W/71118/NMA

Application for a non-material amendment following a grant of planning permission.
Town and Country Planning Act 1990

Non-material amendment following the grant of LU/251115/PC for altered porches, arched heads to rear elevation with windows omitted changes to materials of elevations, removal of chimney & break down head details omitted.

Erection of 3 No dwellings, This application is a departure from the Development Plan

scale	@ A3		date
1:100			January 2018
job no	drawing no	rev	
17110	02.04	1

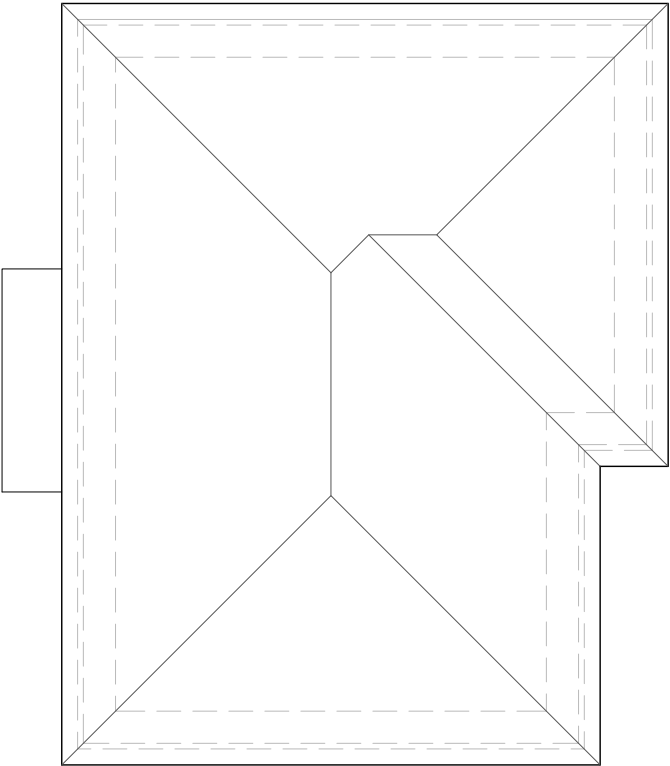
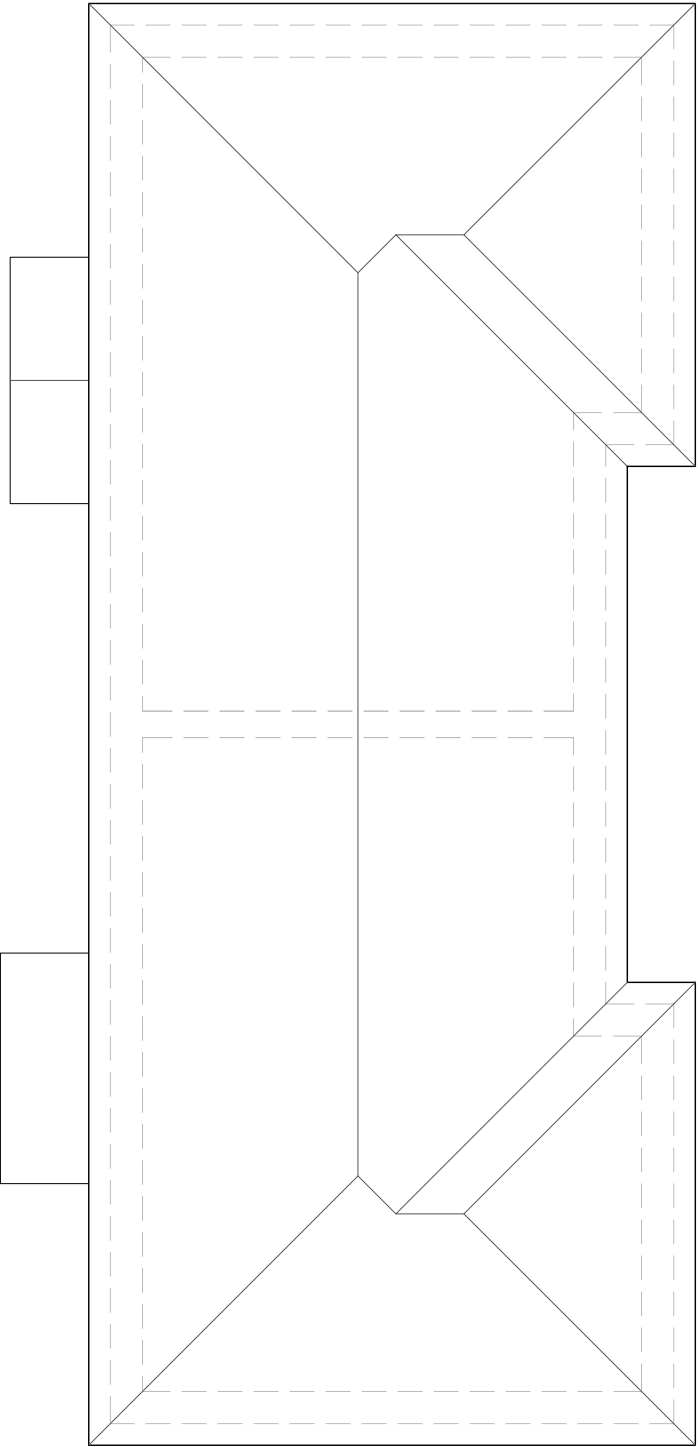
Porches altered
Chimney removed
Rear door head detail omitted
Arched heads to rear elevation windows omitted
Changes to materials on elevations
